27 June 2018
Annie Leung
Team Leader, Key Sites
Assessments

SYDNEY METRO: OVER STATION DEVELOPMENT
VICTORIA CROSS, NORTH SYDNEY
SSD 8874

In response to your letter of 22 May 2018 seeking GANSW comments for the above proposal, we have reviewed the information provided and provide the following advice and recommendations.

WEST ELEVATION

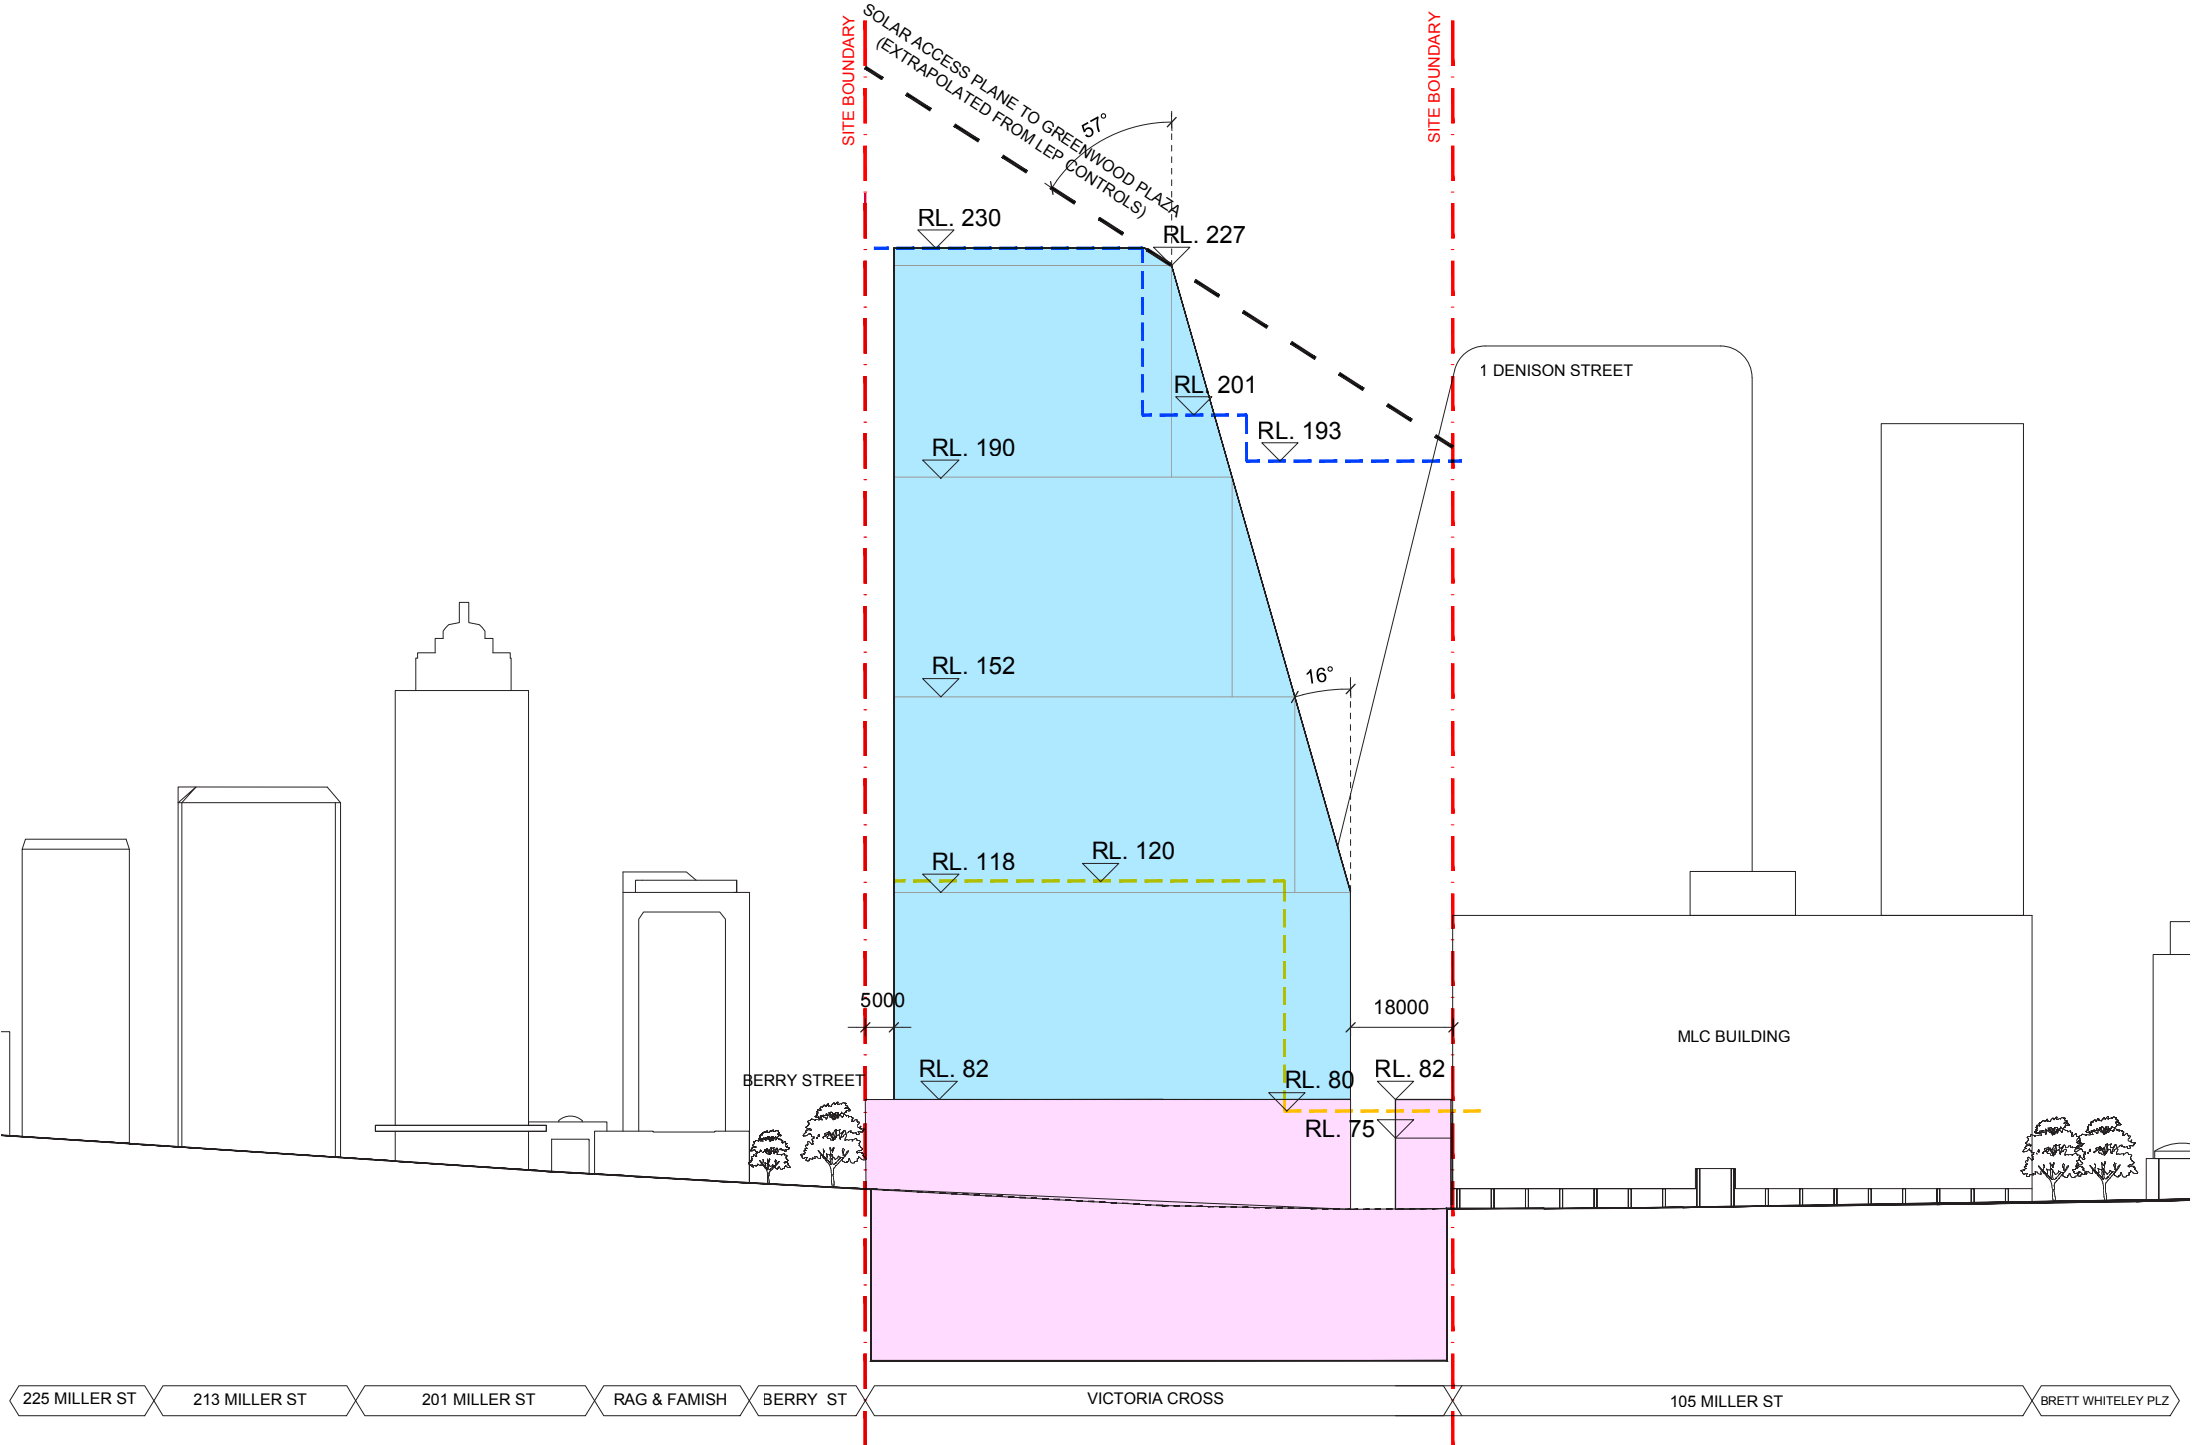
- *Western stepping* - the outward stepping of the Miller Street façade, with upper levels of the building progressively projecting up to 4.5m over the footpath, should be reconsidered. This massing strategy impedes the sky view from Miller Street and creates an uneasy sense of the building towering over the public domain.

9.1 INDICATIVE DESIGN ELEVATIONS

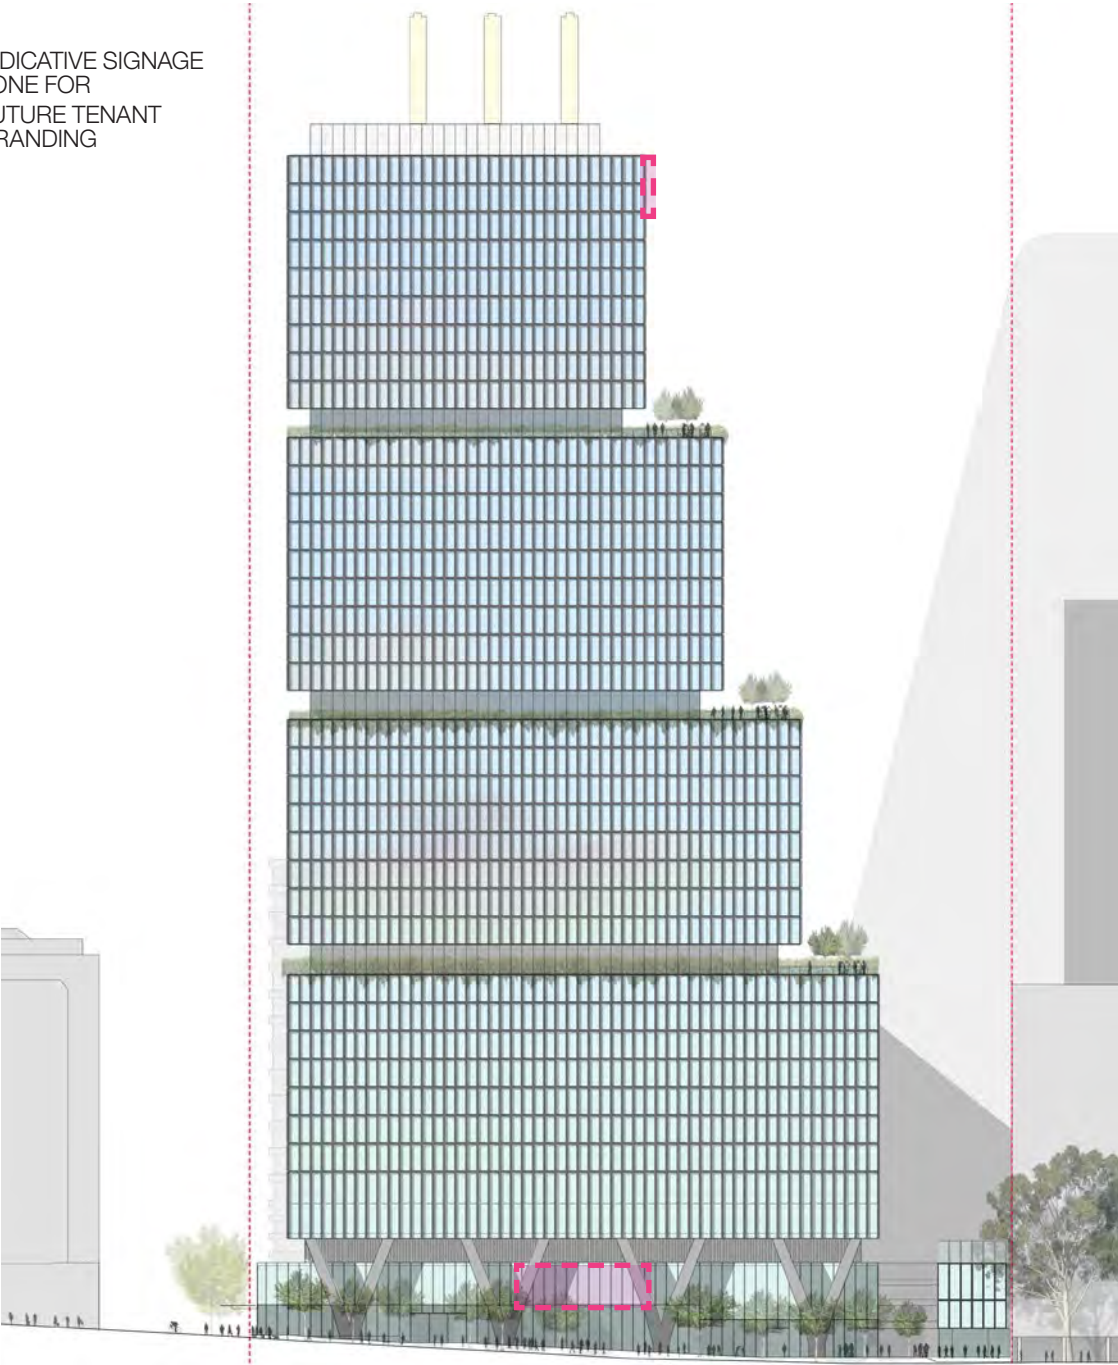
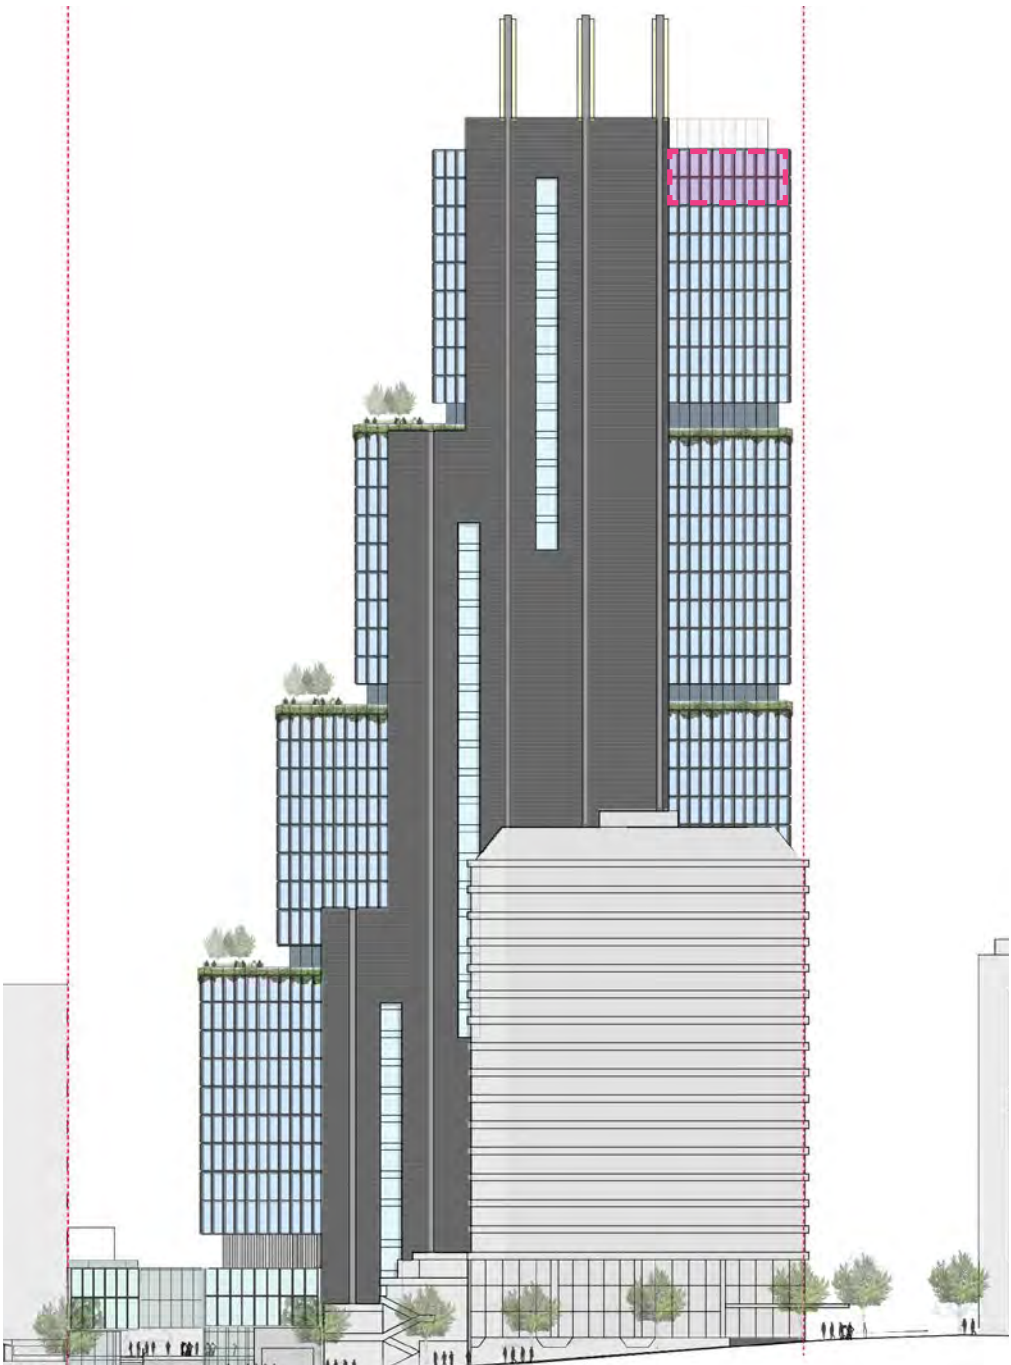
- *architectural roof feature* - Architectural elevations in Appendix E show three fins, each approximately 3.5 storeys tall. While these are shown indicatively, it is recommended that building elements outside the building envelope not be permitted, due to the extent of height increase already under consideration.
